**WELWYN HATFIELD BOROUGH COUNCIL
EXECUTIVE DIRECTOR - PLANNING, PUBLIC PROTECTION AND GOVERNANCE**

DELEGATED APPLICATION

Application No: 6/2017/0309/ADV
Location: VW Van Centre Harpsfield Broadway Hatfield AL10 9TF
Proposal: Installation of 4 x illuminated fascia sign, 2 x Free Standing sign
Officer: Mr R Adenegan

Recommendation: Granted

Proposed Elevations

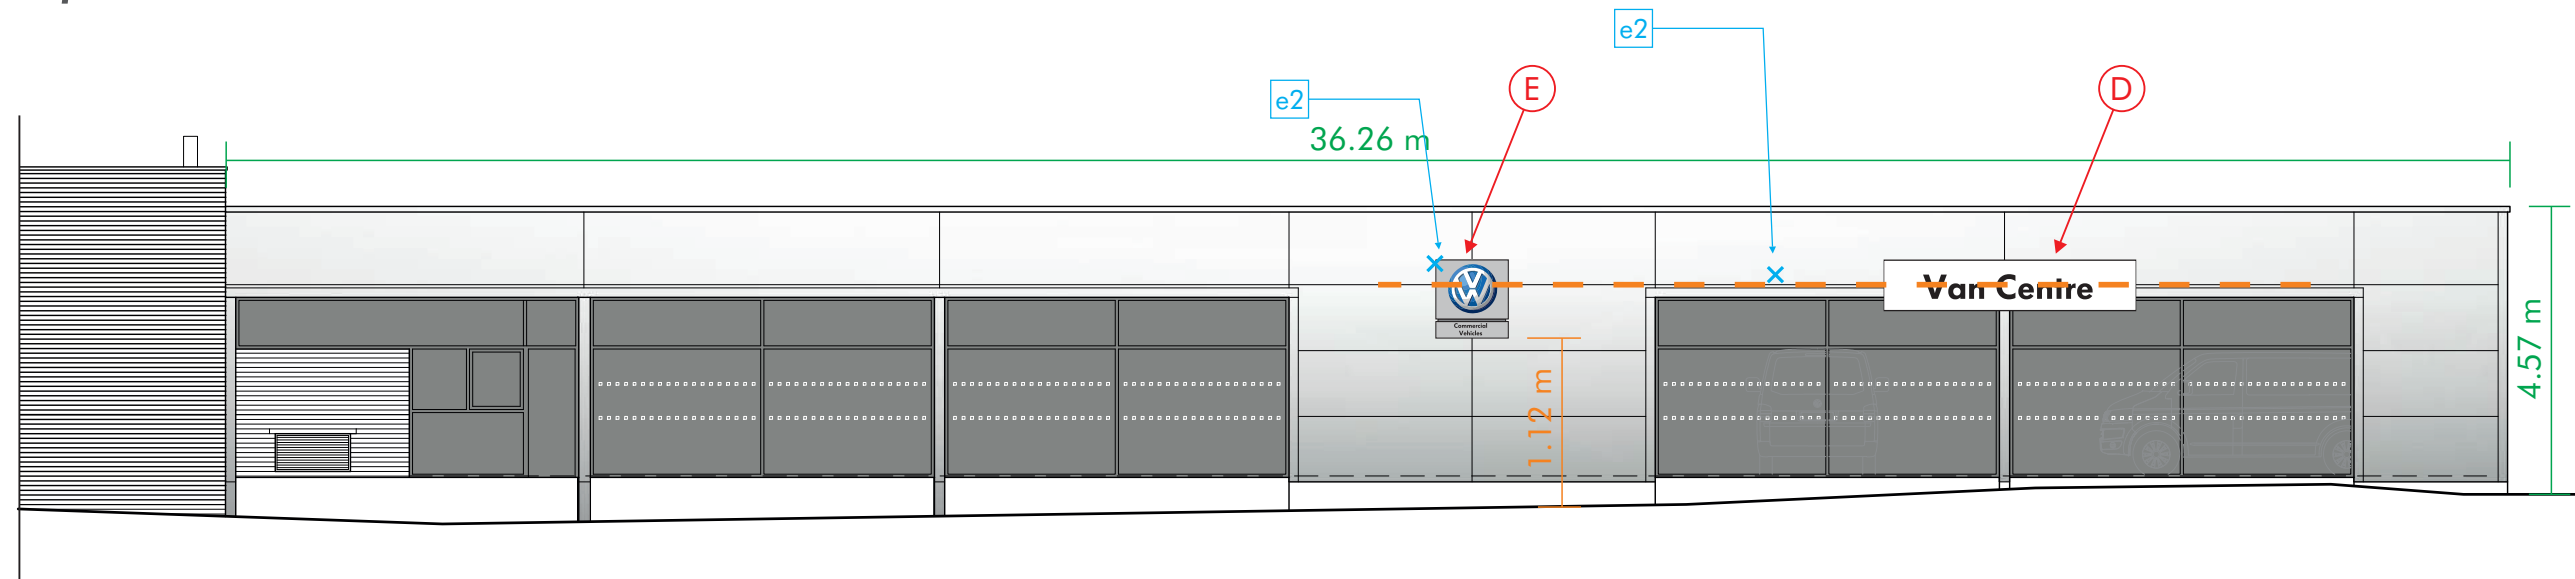
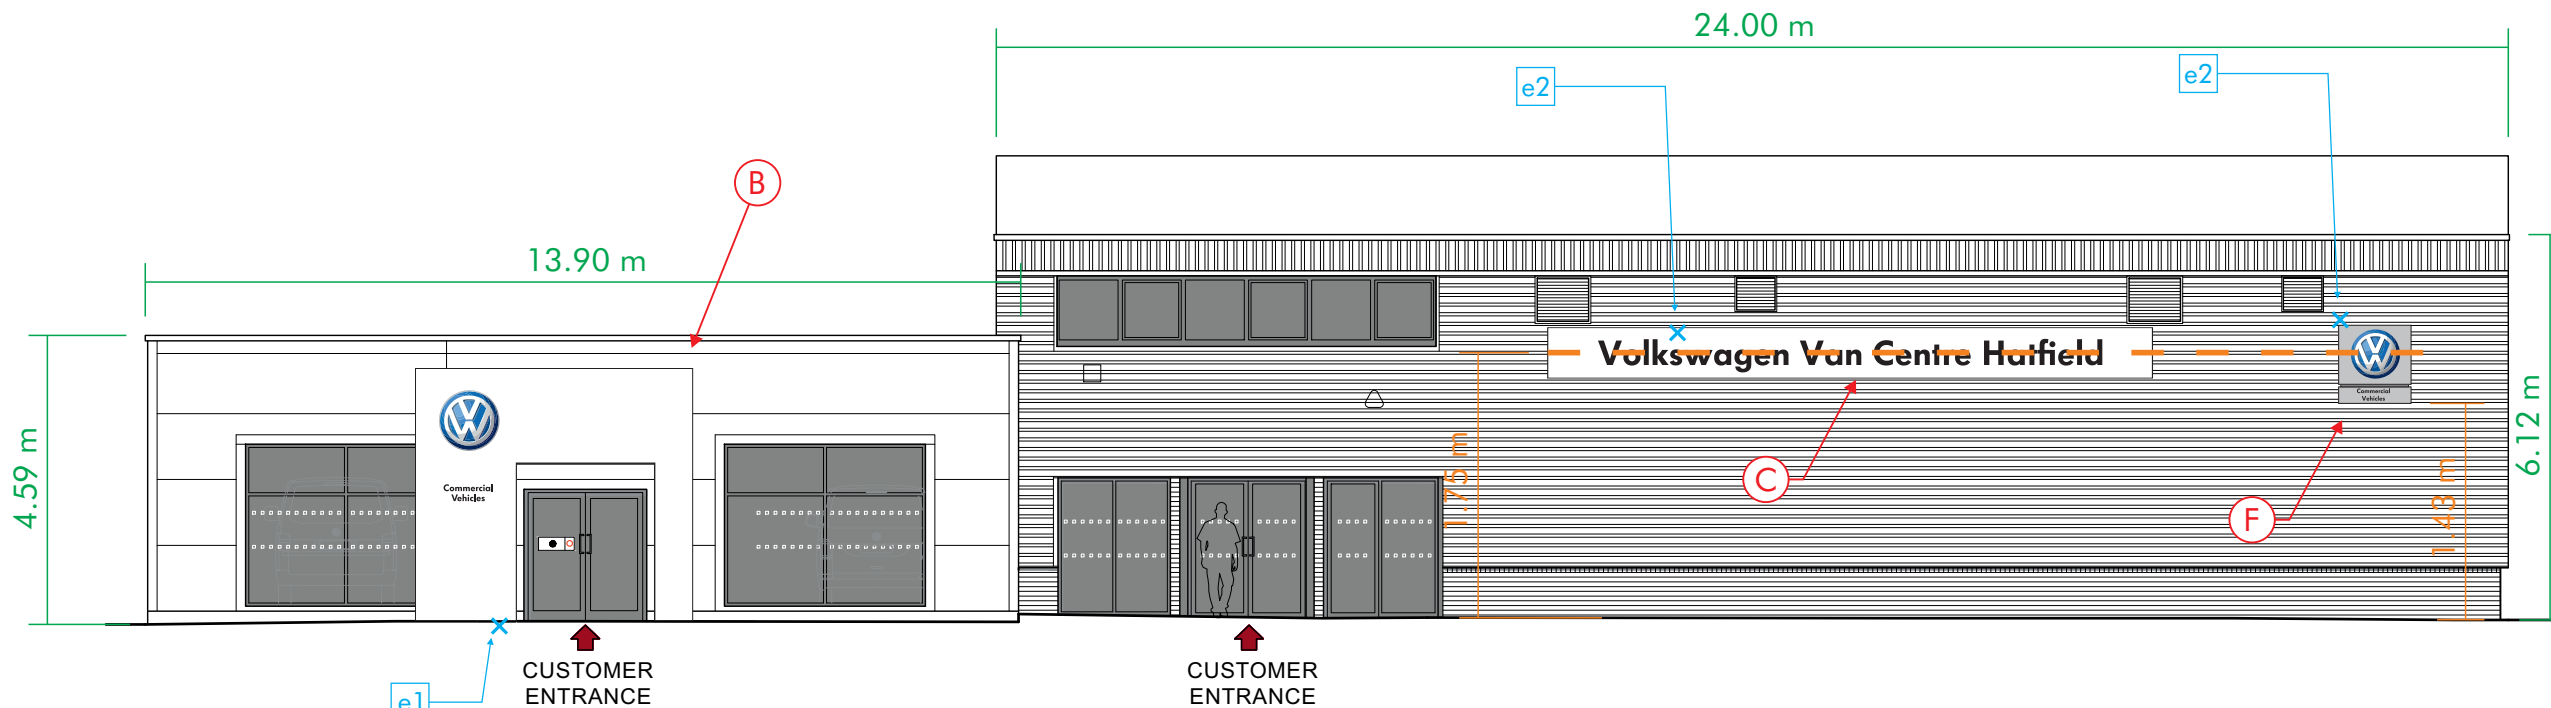
- (1) The host building and site are large in their scale. The proposed fascia signs would be replacements for those as existing and would be relatively similar in scale, character and design with the exception of colour change from white to blue. The proposed free-standing signs to the front of the site would remain subordinate to the building(s) and the site, and reflect the scale of the building and site to which they relate.

- (2) The proposed fascia and wall mounted signs on the host building are of a suitable size and logically positioned so are to ensure that the architectural features of the building are respected

## Sign A - VWCV Pylon Sign

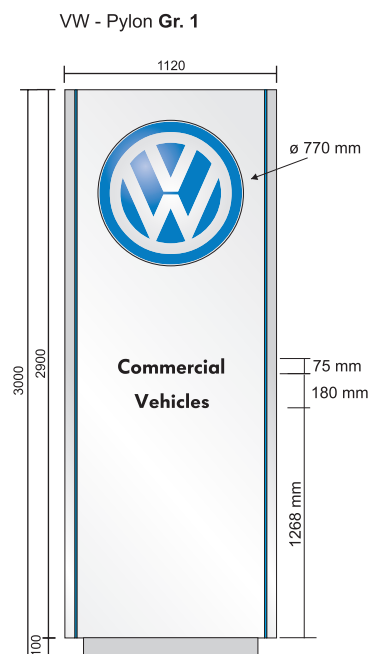
- (3) The free-standing pylon/totem are considered to be well spaced in logical positions which would be considered acceptable in this regard. There currently 8 advertisement flags on site at the time of the Officer's visit. These flags do not form part of this application. The plans which have been submitted do annotate existing flag advertisements.

- (4) All illuminated signs proposed would be internally illuminated to a luminance level of between 260 cd/m to 300cd/m, and as such, comply in regards to being illuminated by discreet means. The size, spacing and design of the proposed advertisement ensure that they would not appear visually intrusive or dominant.
